Date: 30 June 2026
Our ref: 551705
Your ref: EN010148

NSIP Reference Name / Code: Tween Bridge Solar Farm / EN010148

Title: Natural England's comments for Deadline 3 in respect of the Tween Bridge Solar Farm Project, promoted by RWE Renewables UK Solar and Storage Limited.

**Figure 1: Pond Location Plan - Overview**

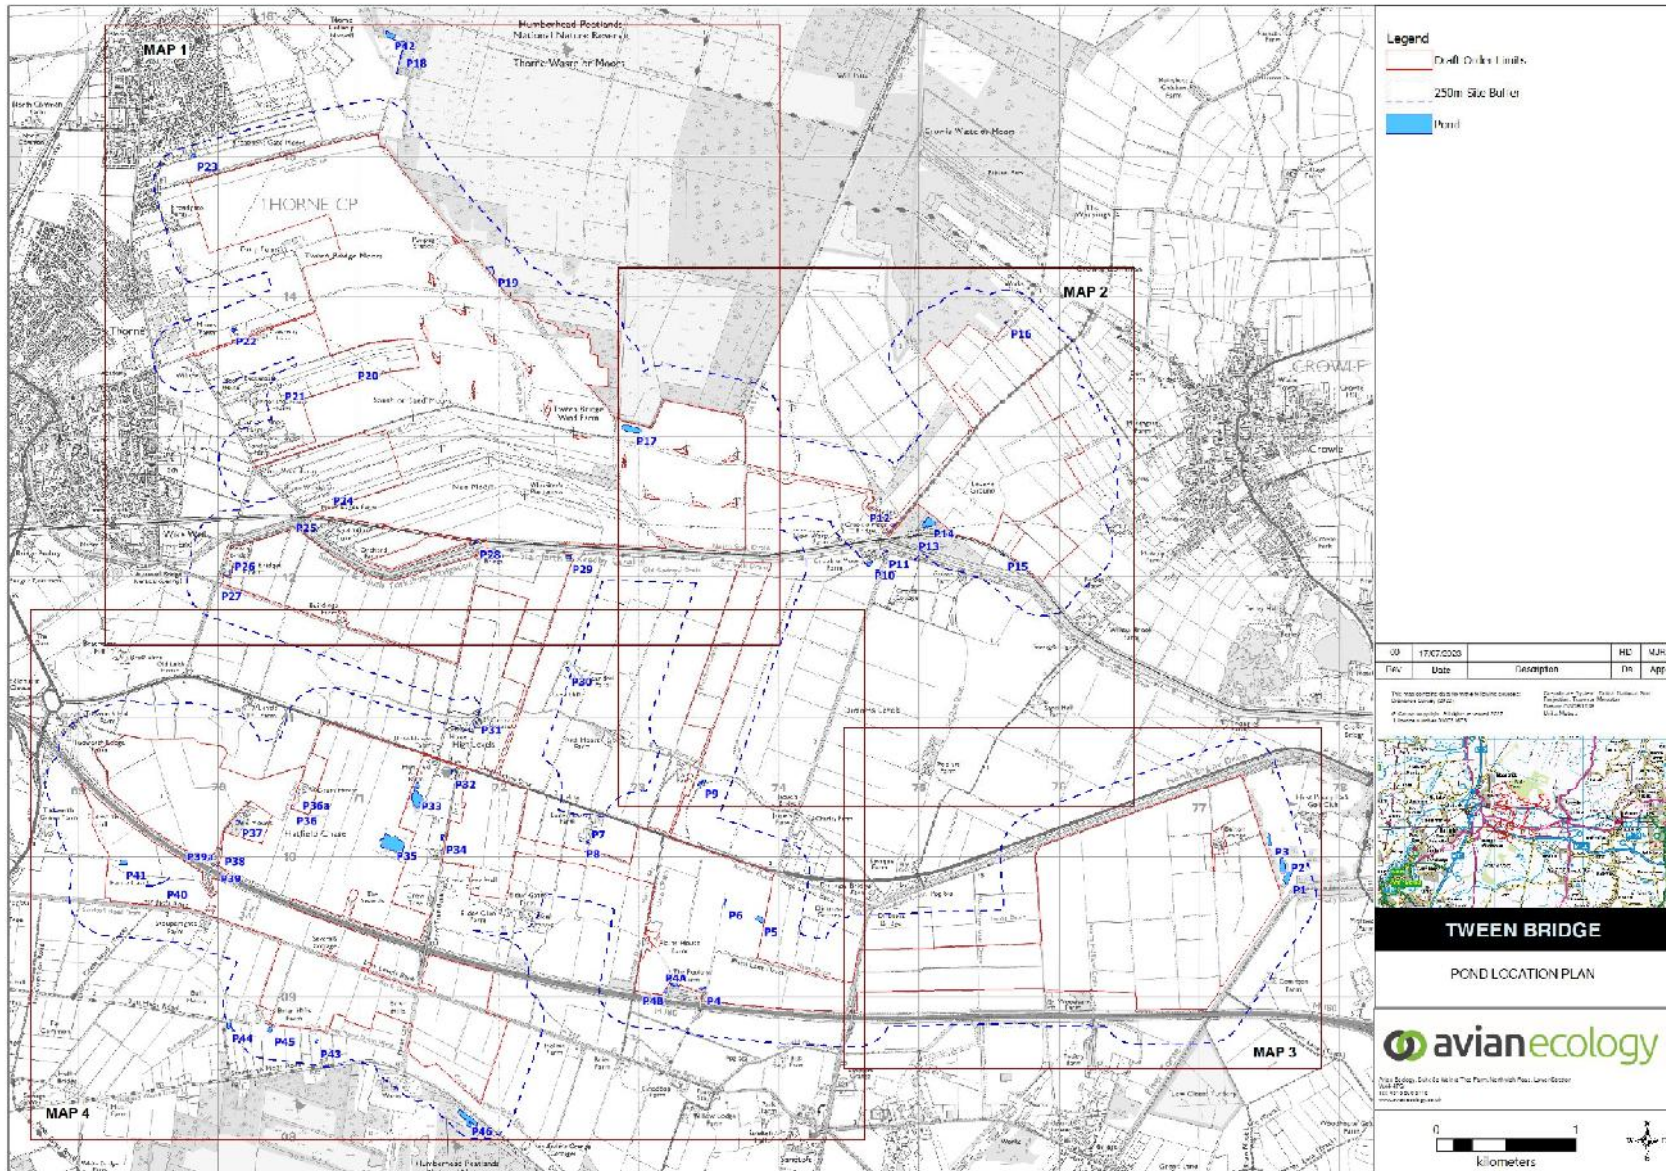
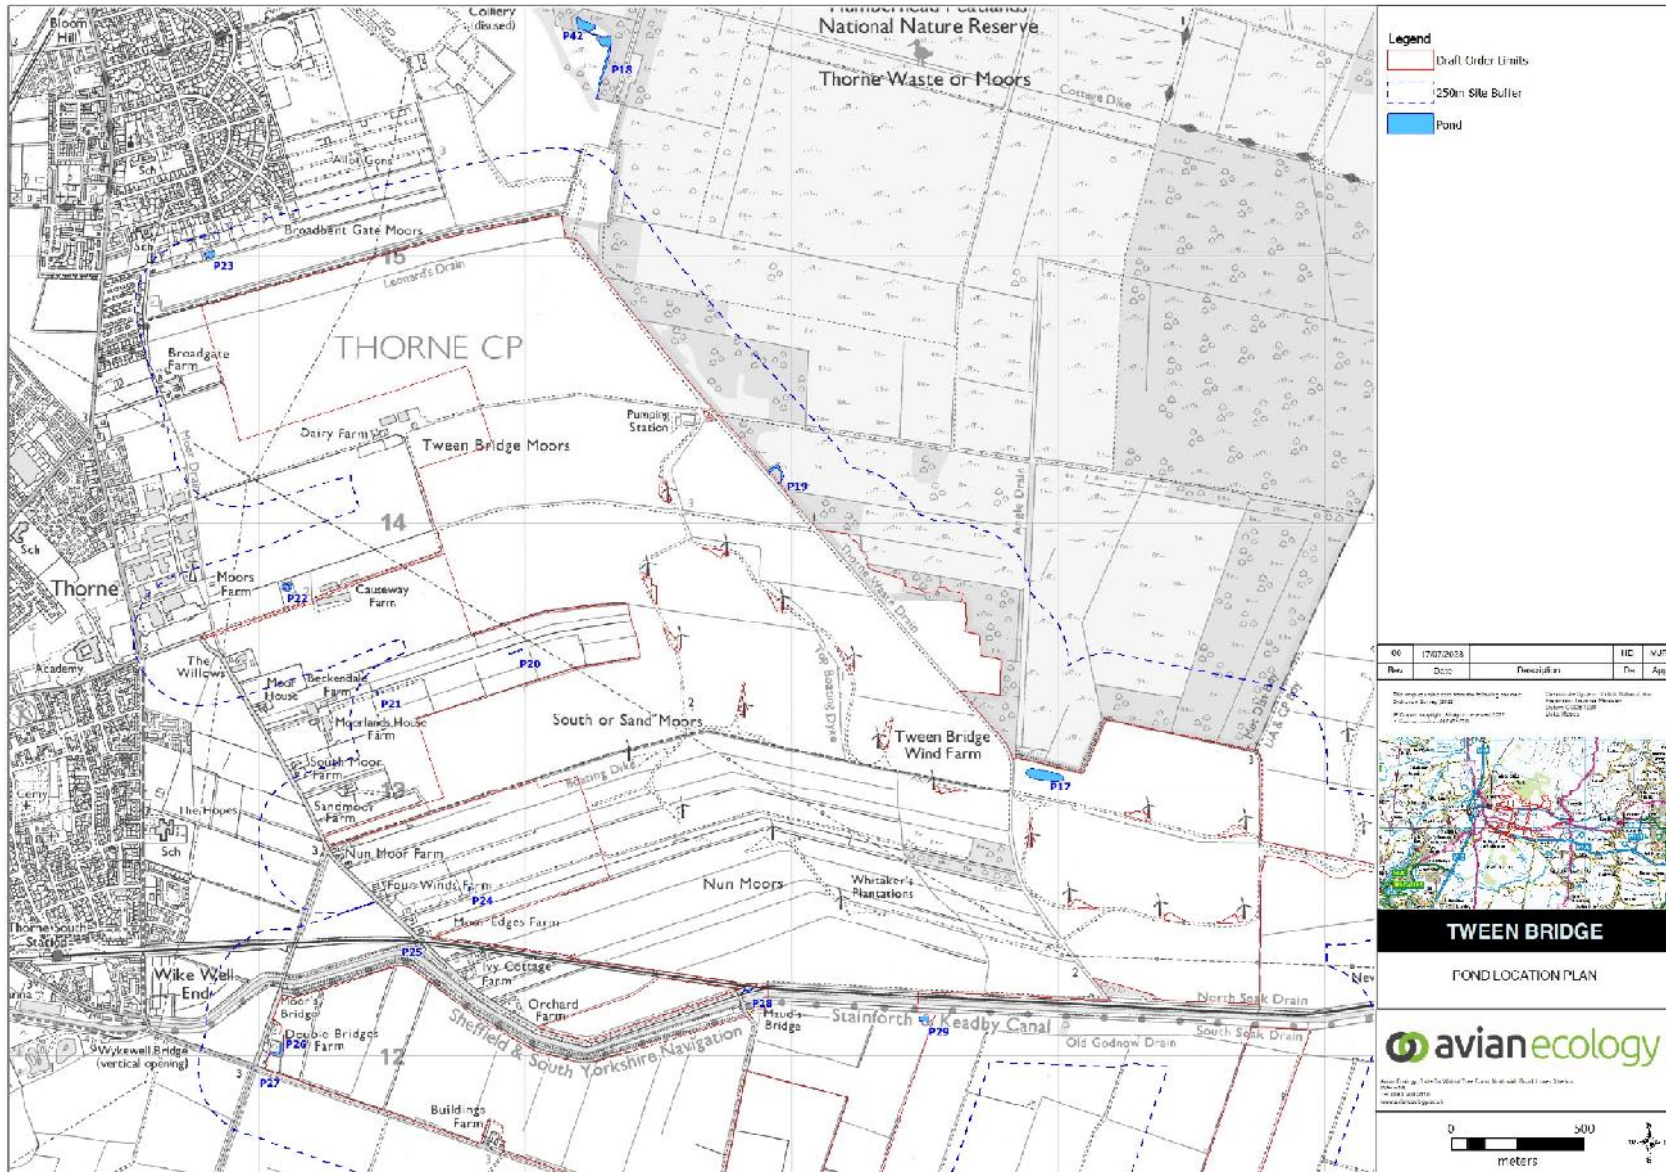
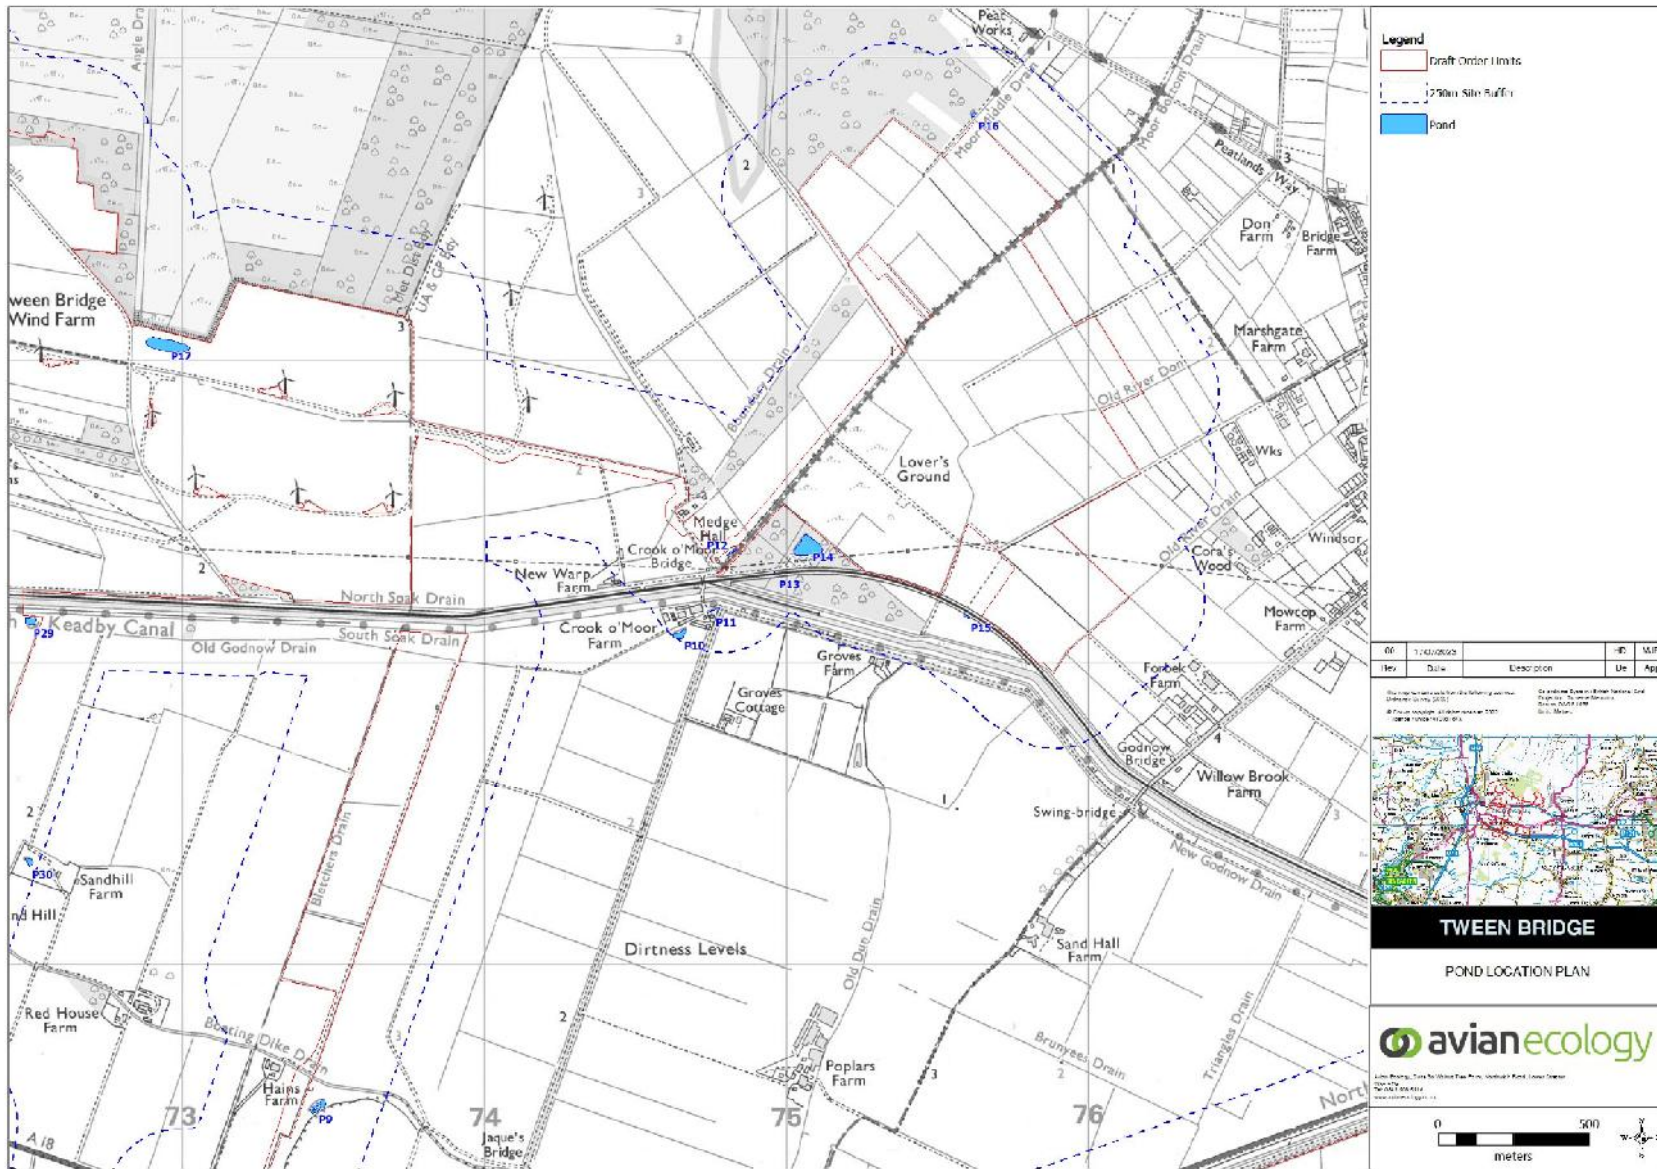
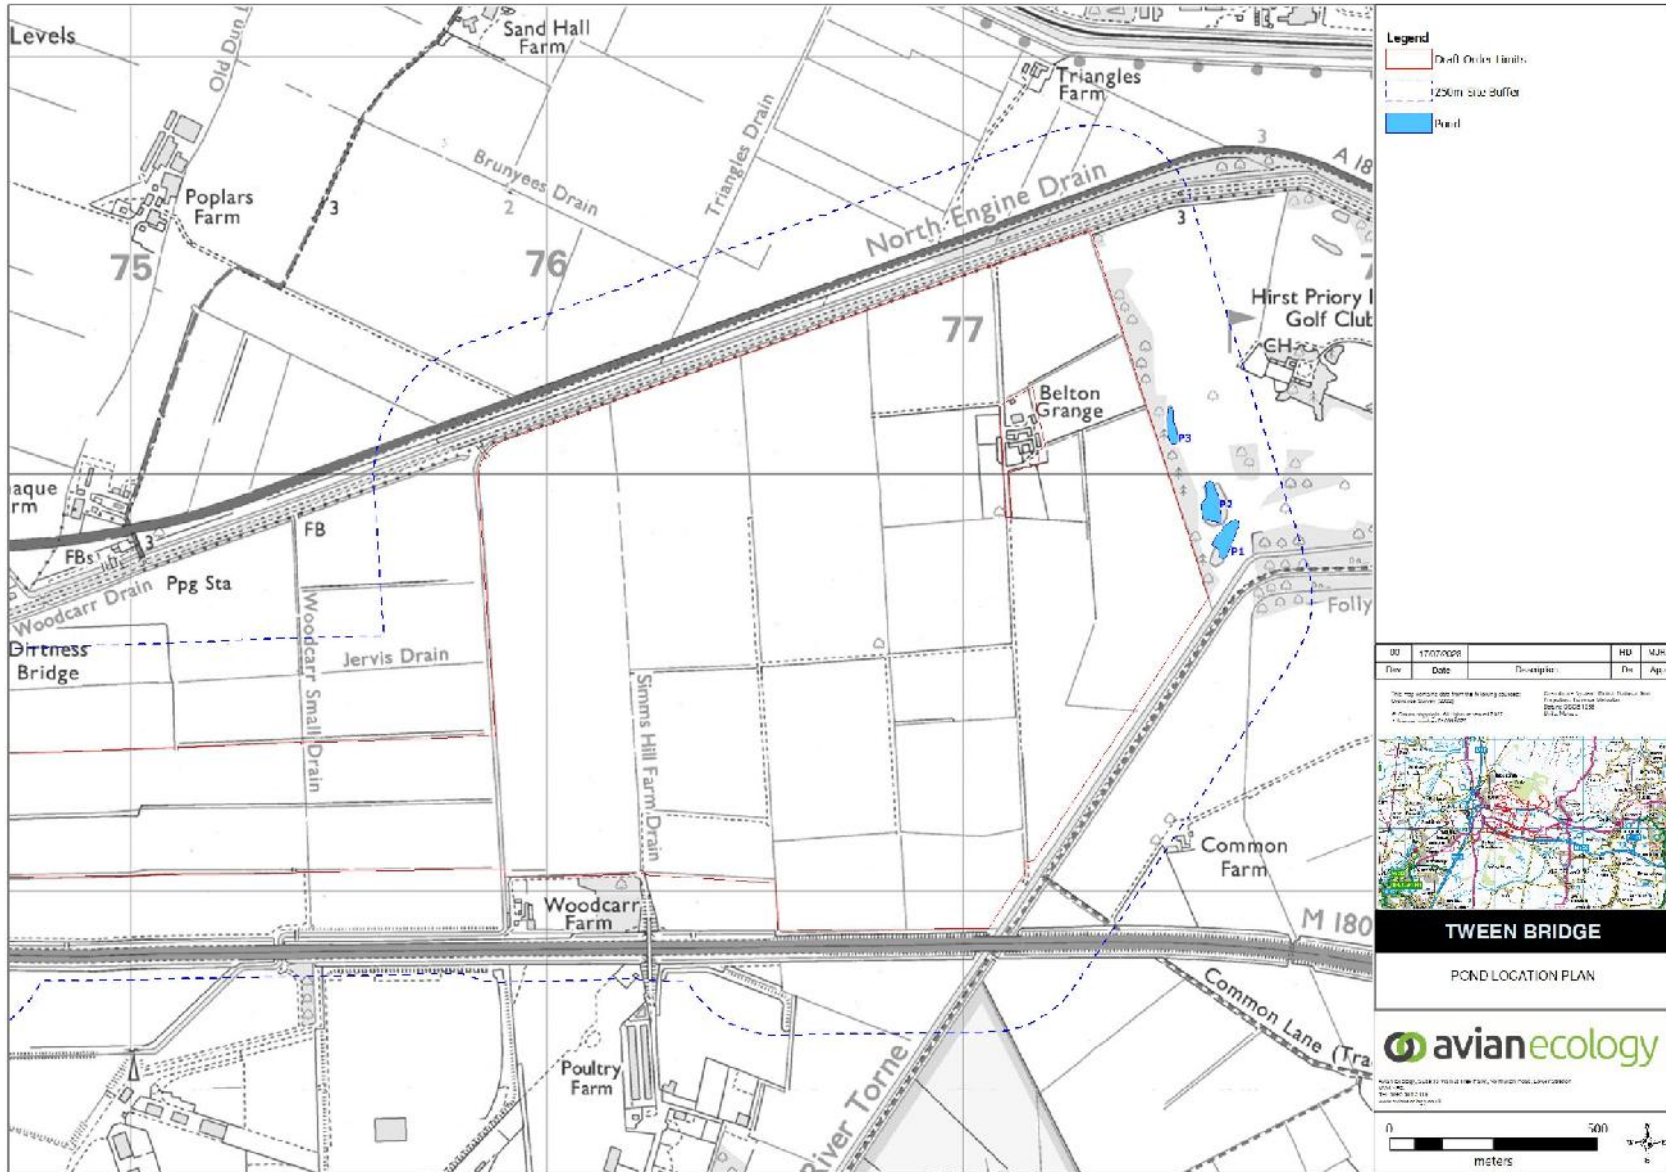
Natural England advise that this point is now resolved.	
NE23d	Protected species	Protected species – Great crested newt	<p>Natural England advise that the current survey effort is insufficient to provide robust evidence of Great Crested Newt presence/absence across the scheme footprint, with it noted that almost half of the scheme’s ponds remain un-surveyed and inaccessible. As such, it is not currently possible to conclude that Great Crested Newts are absent from the site, and their presence cannot be ruled out in un-surveyed areas.</p> <p>To address this uncertainty, we recommend that further survey work should be undertaken. Where this is not possible, a precautionary approach should be adopted, whereby Great Crested Newts are assumed to be present in the areas of highest habitat suitability where there are historical records of the species.</p> <p>Natural England recommends that where access permission to land or waterbodies are denied, we would expect that an effort is made to repeat these access requests. Evidence should be retained to show what efforts have been made to seek access and, should a full licence application eventually be needed, Natural England may request to view these records.</p> <p>Where access is continually denied, or ponds continue not to be surveyable, Natural England recommend that alternative sources of information, such as historical records and terrestrial habitat mapping, should be used to assess the ‘reasonable maximum’ population of great crested newts that the un-surveyed parts of the site could support, with the scheme designed accordingly.</p>	Amber
